ENG-SF22025-R4-FDR.pdf Markup Summary

CREEK ACCESS

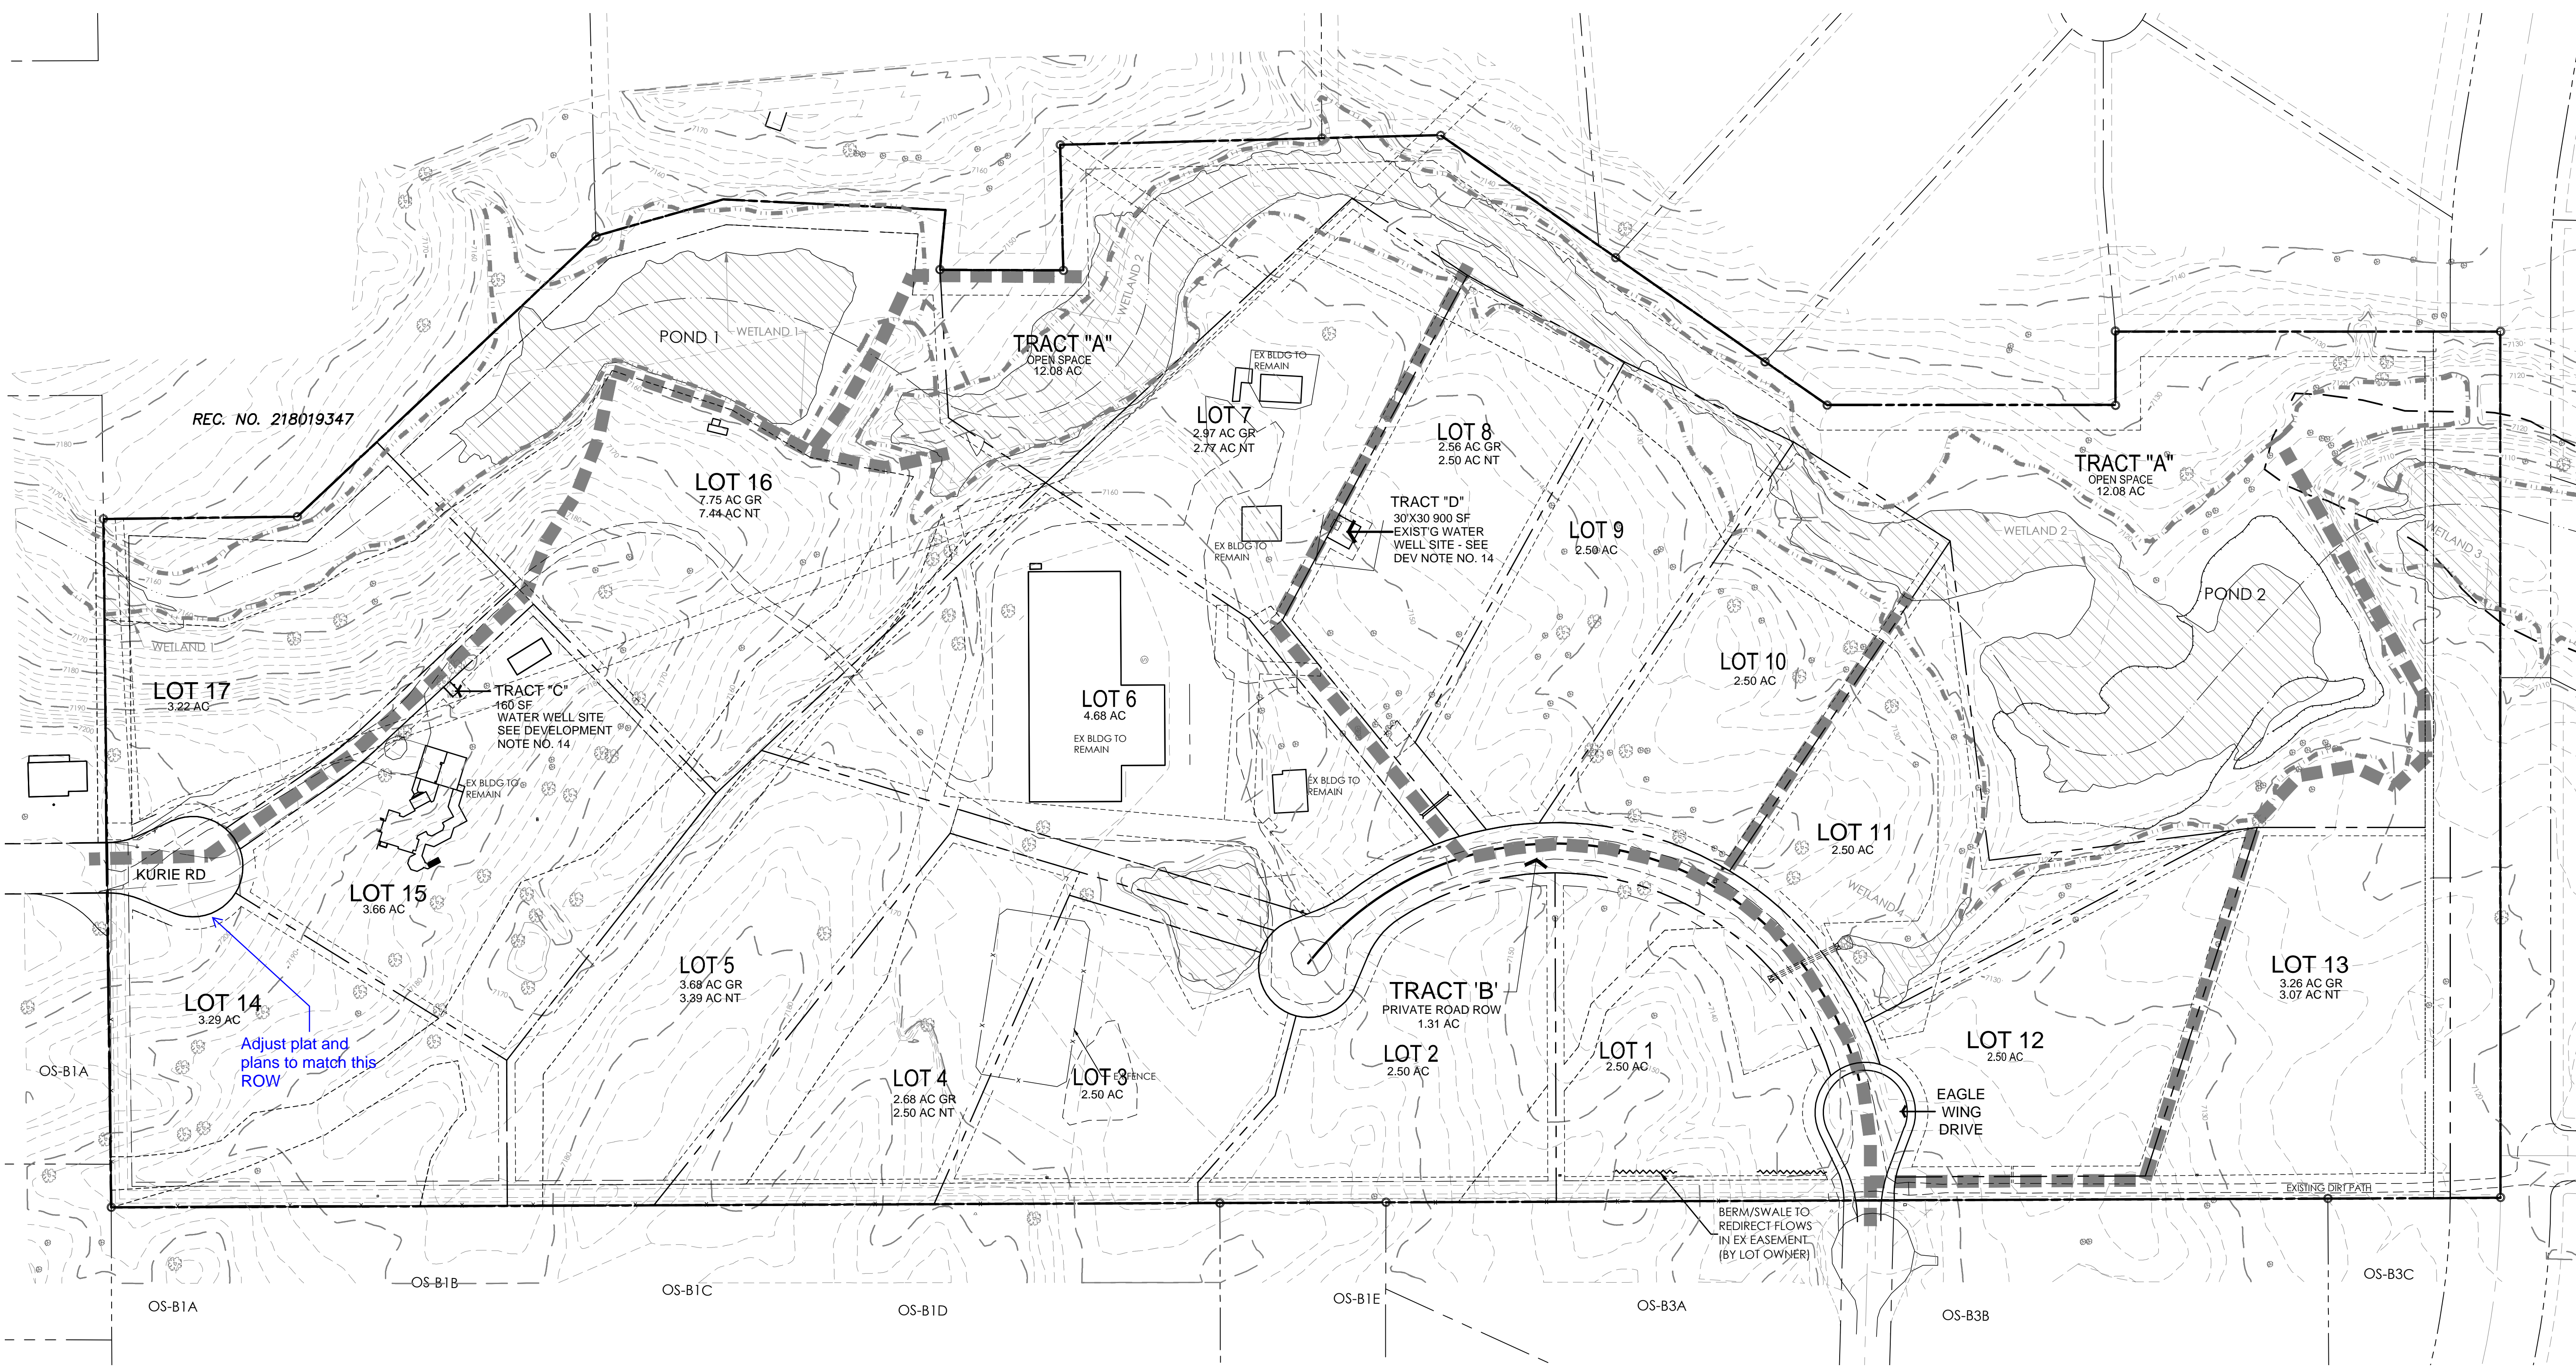
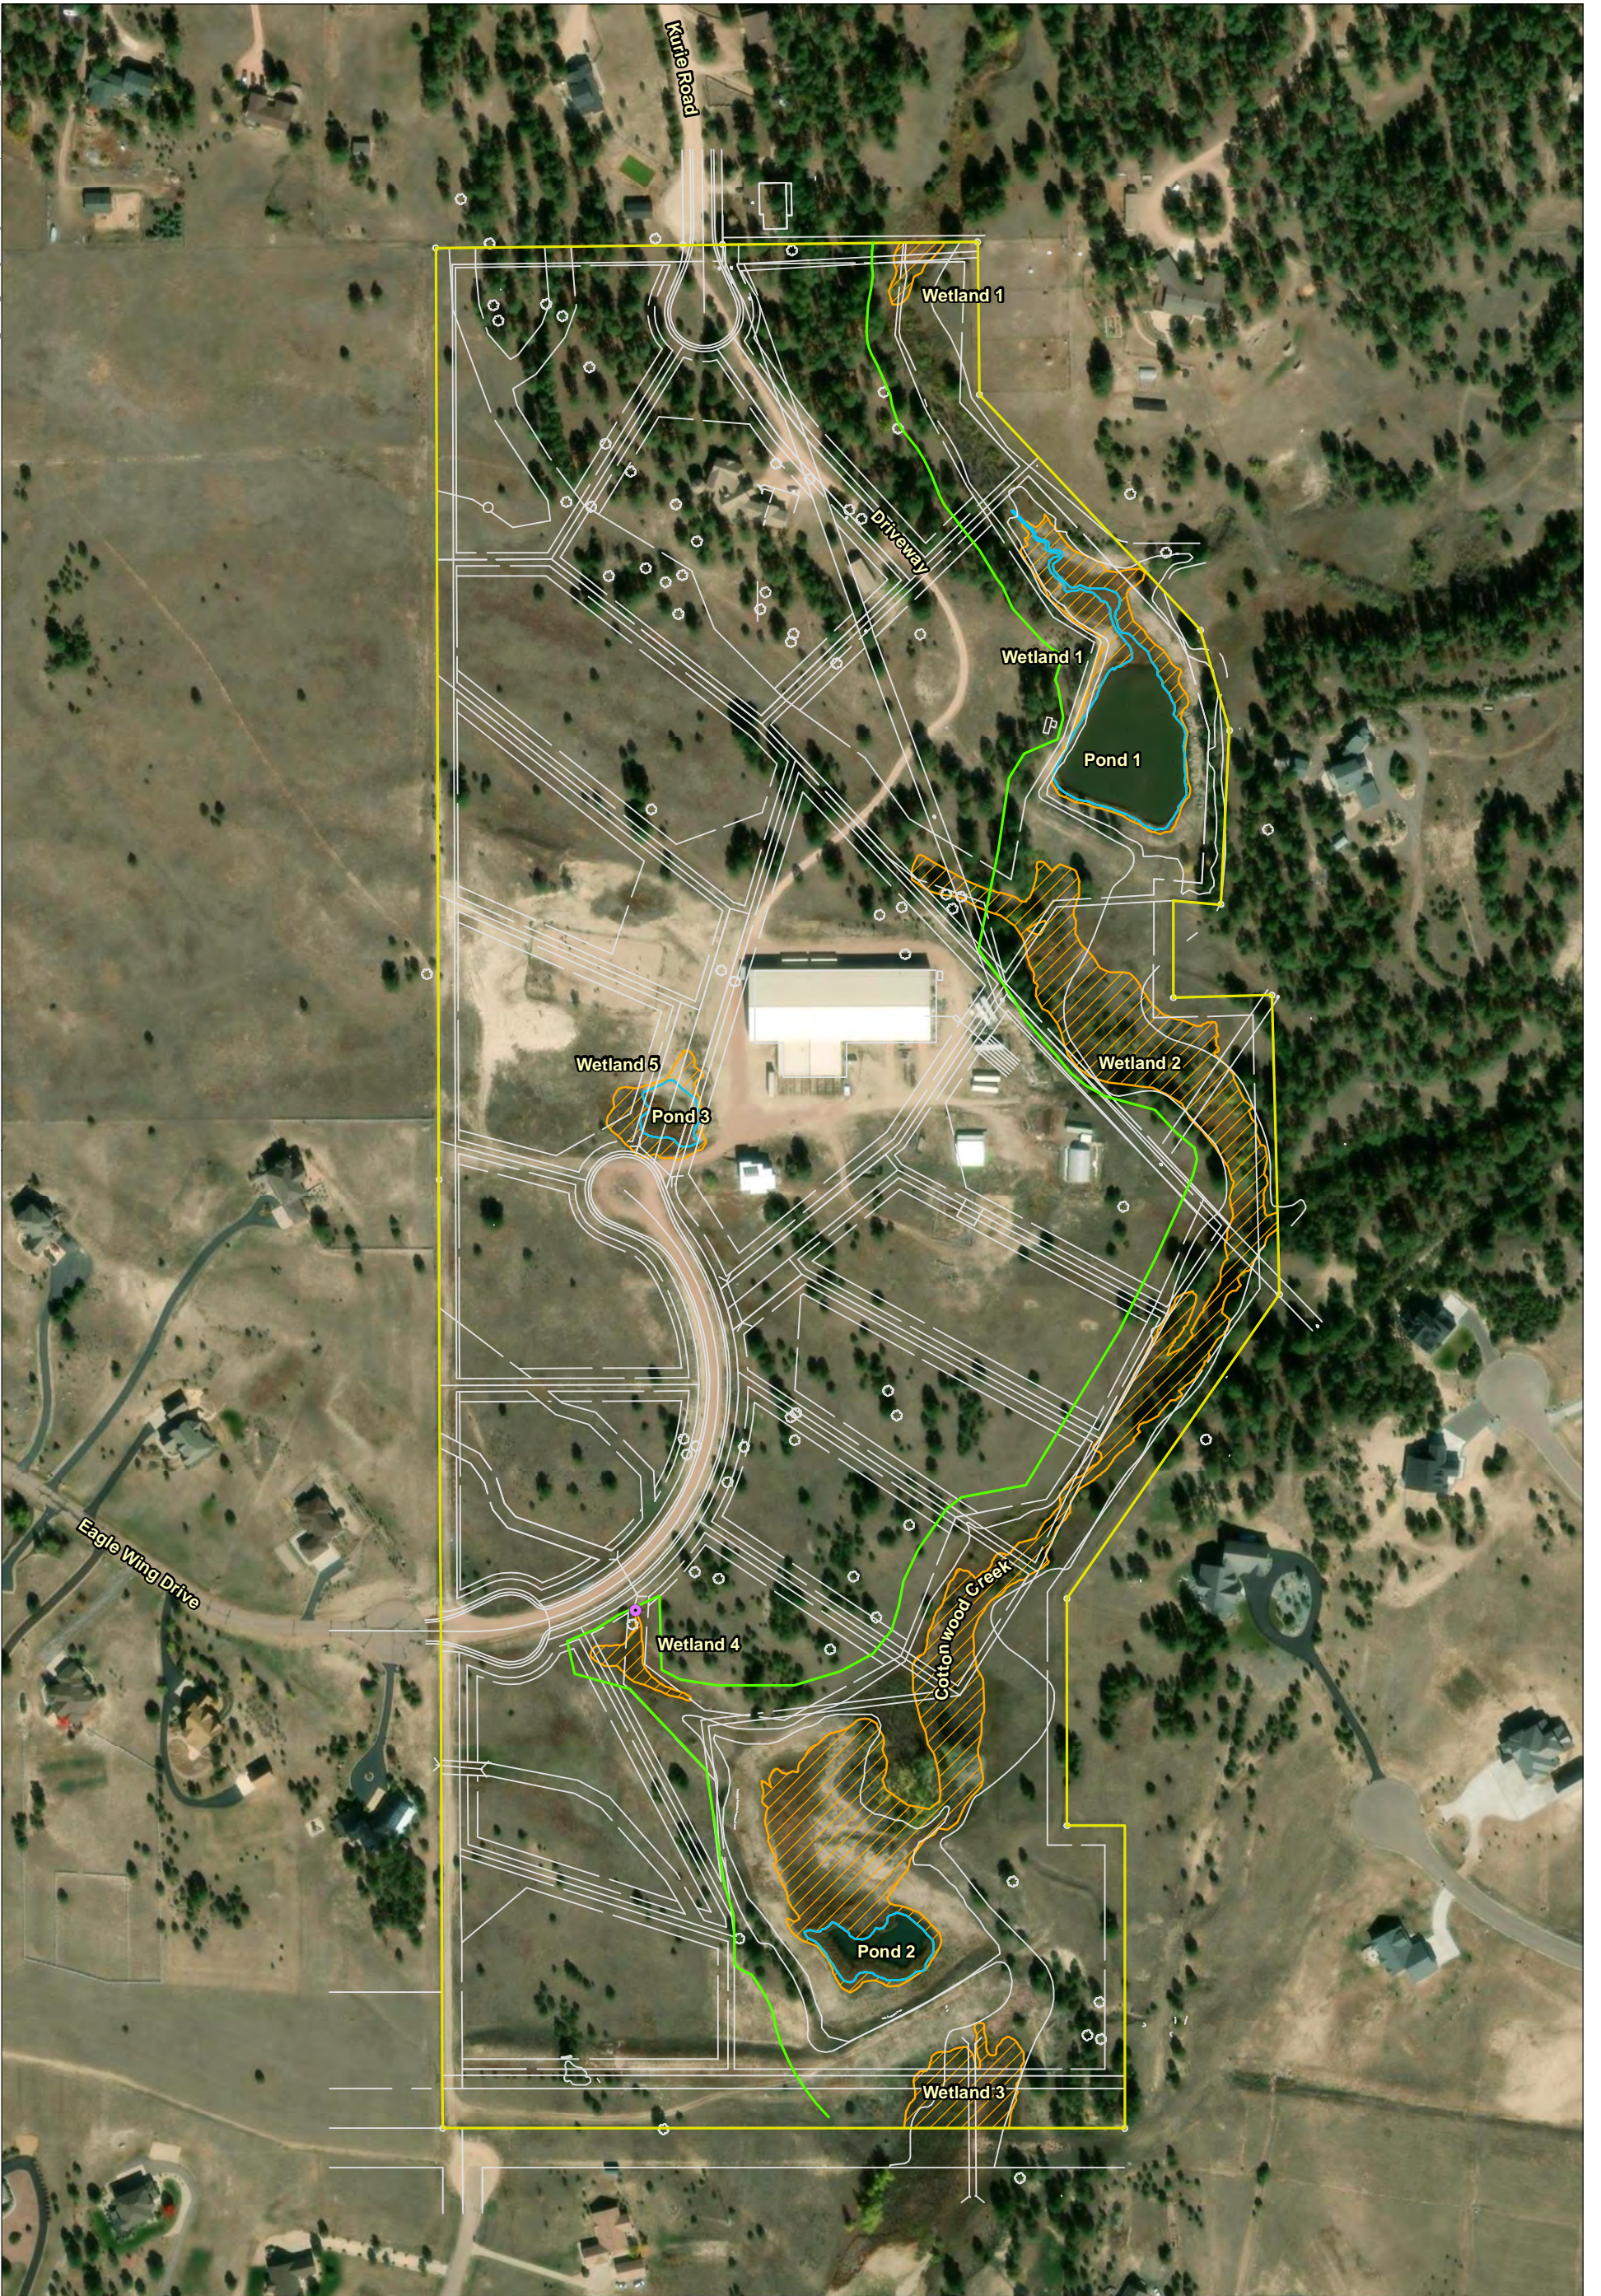
Delete "possible"

Unresolved: Label proposed widths and maximum grades on all access routes. (one note can be provided)

Adjust plat and plans to match this ROW
